PLANNING CONSULTATION RESPONSE

Application No	2026/0217
Proposal	Erection of 1st floor side extension and 2 storey front extension, velux windows to front, dormer and balcony to rear of dwelling.
Address	Cawthorne Old Barn, Brook Houses Taylor Hill, Cawthorne, Barnsley, S75 4EZ
Date of Consultation Reply	13.04.2026
Consultee	Charlie Atkinson Design & Conservation Assistant

<b>PLANNING</b>				
CLIENT Mr & Mrs Milner				
PROJECT Brook Houses, Cawthorne				
TITLE Proposed Elevations				
CREATION DATE Mar 2026	SCALE @ A1 1 : 50	DRAWN CW	CHECKED CW	STATUS 53
SHEET NO. MILNER - CW - B01 - XX - DR - A - 10-201	REVISION 1

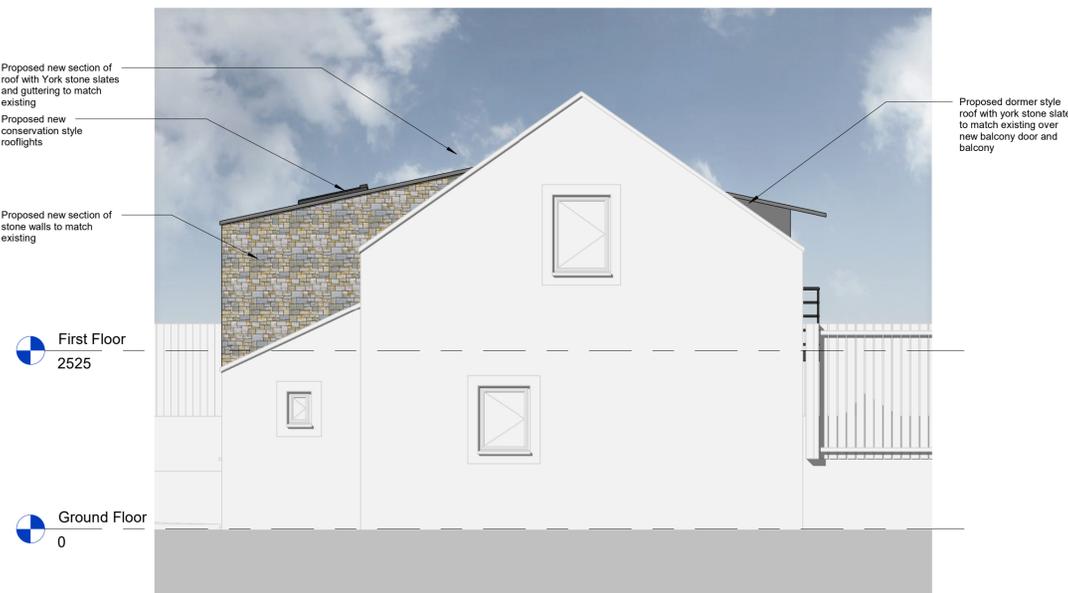
The proposed first-floor side extension and two-storey front extension, together with the associated roof alterations, are considered unacceptable in their current form. The changes shown in the proposal would result in an alteration that is unsympathetic to the character of the converted barn due to overbearing and overtly domestic changes not in keeping with historic precedents. The impact of the side and front extensions, combined with the roof alterations, would significantly alter the simple and functional appearance of the building, which would in turn erode its contribution to the conservation area. Currently, despite changes that have already occurred, the former agricultural and historic use is clear from its appearance. As such, the building makes a positive contribution to the character, appearance, and group value of the conservation area.

However, the current proposal, and particularly the introduction of a two-storey front extension, is considered harmful to the character and appearance of both the building and the conservation area. The extent of the extensions and roof alterations would introduce a more domestic form and appearance that conflicts with the building’s historic agricultural character. It is noted that an alternative roof form, such as a catslide roof, may offer a more sympathetic solution; however, this would require careful consideration and the submission of detailed plans.

It is therefore recommended that the scheme is reworked, including the removal of the front extension and a reconsideration of the roof form and pitch, to better reflect the character and appearance of the existing converted barn. It is also suggested that the applicant seeks pre-application advice, for any future development, to obtain initial guidance prior to the submission of a proposal.

This has been achieved through the introduction of a catslide roof, the replacement of the balcony with conservation rooflights, and an overall design approach that reflects a more traditional appearance in keeping with the original building.

CREATION DATE	SCALE @ A1	DRN	CHK	STATUS
Mar 2026	1 : 50	CW	CW	53
SHEET NO.	MILNER - CW - B01 - XX - DR - A - 10-201		REVISION	
			2

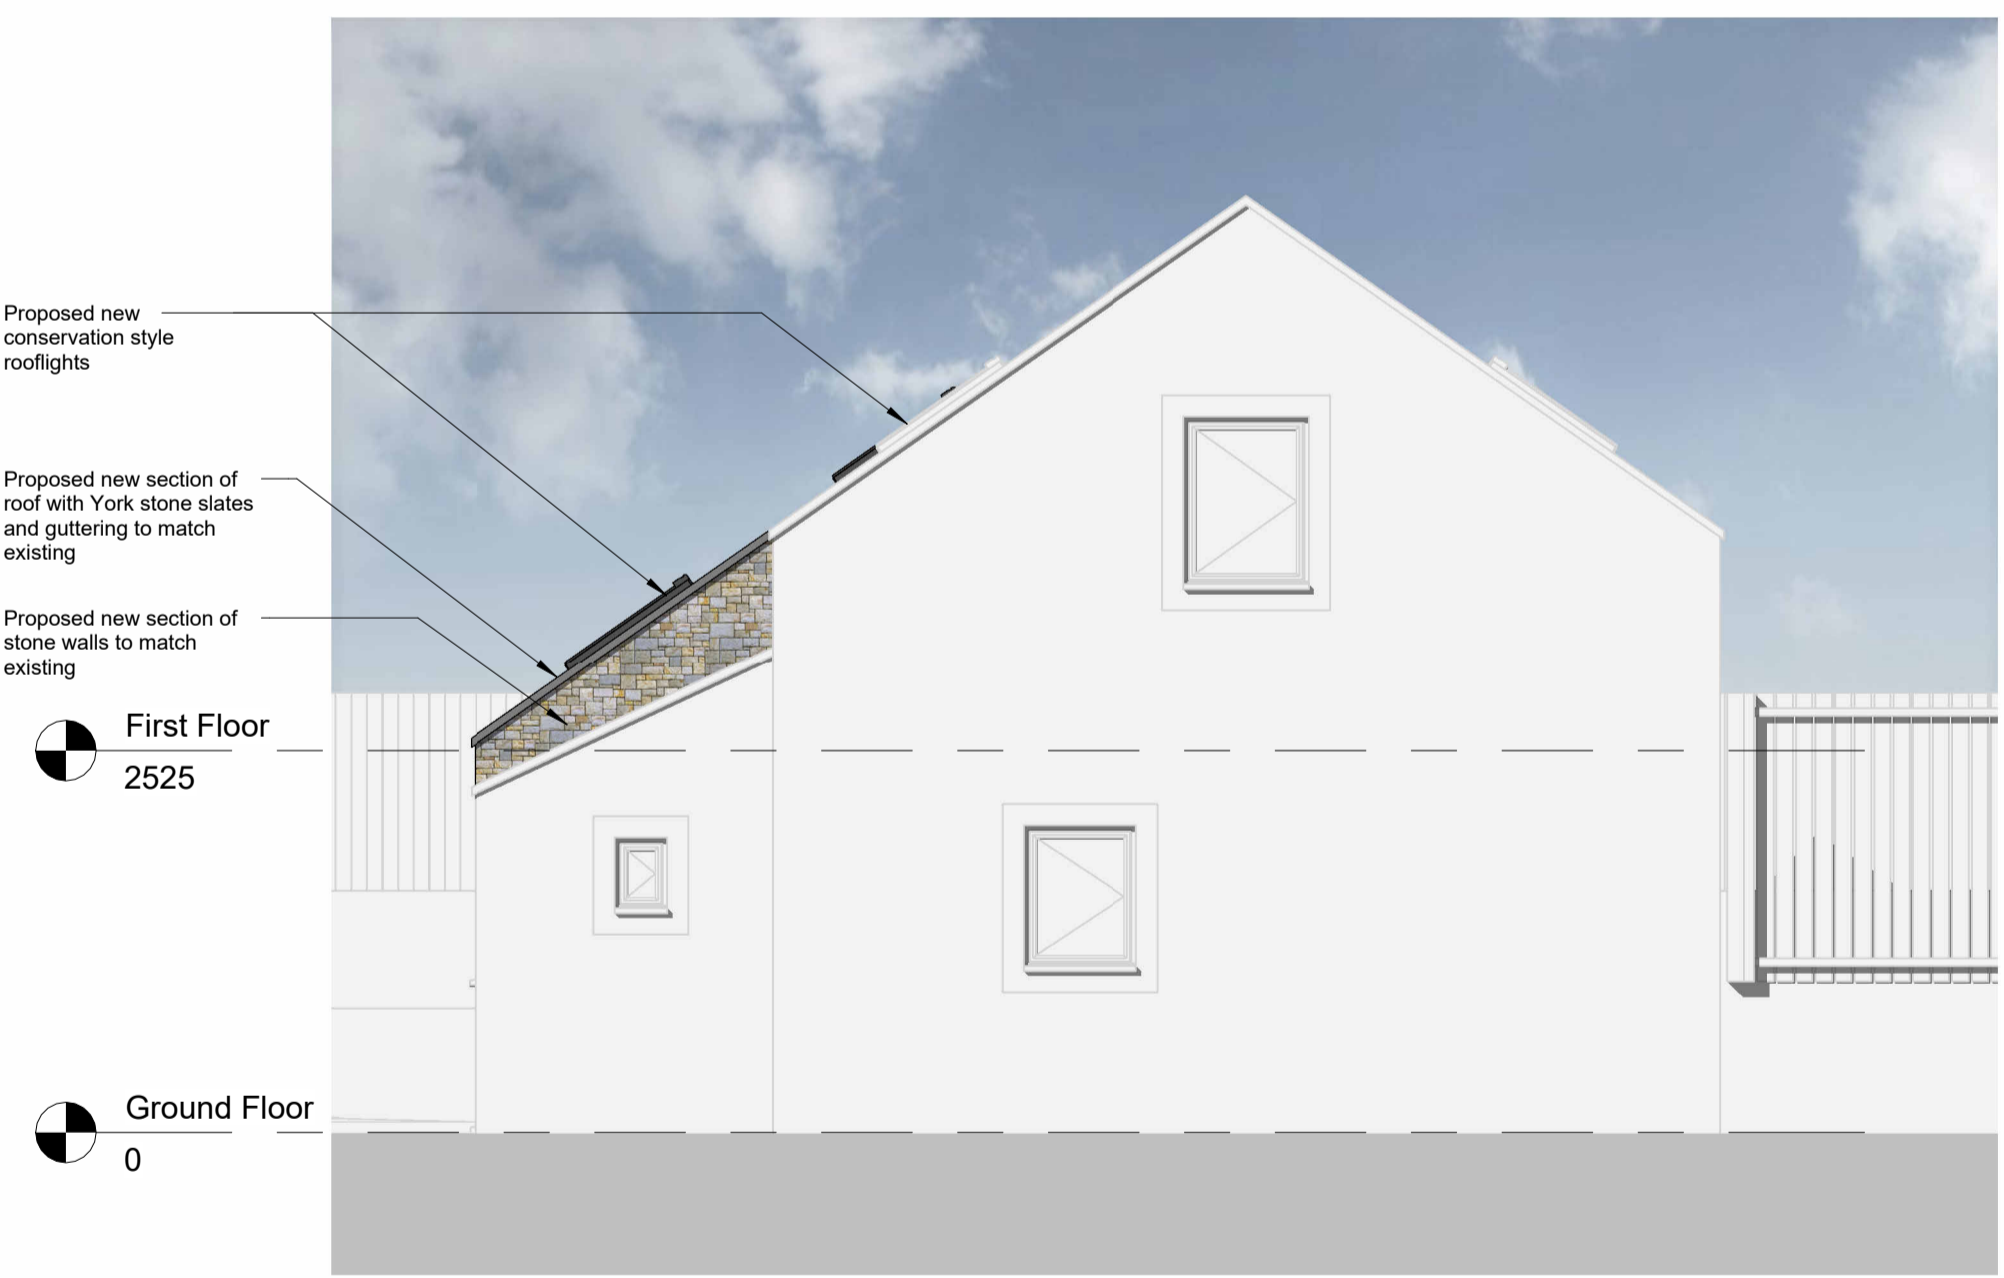
The applicant has taken into consideration the recommendations set out in the above comments and has put forward a more appropriate proposal, which better respects the architectural and historic interest of the Old Barn (circa 1850), as well as the character and appearance of the Cawthorne conservation area.
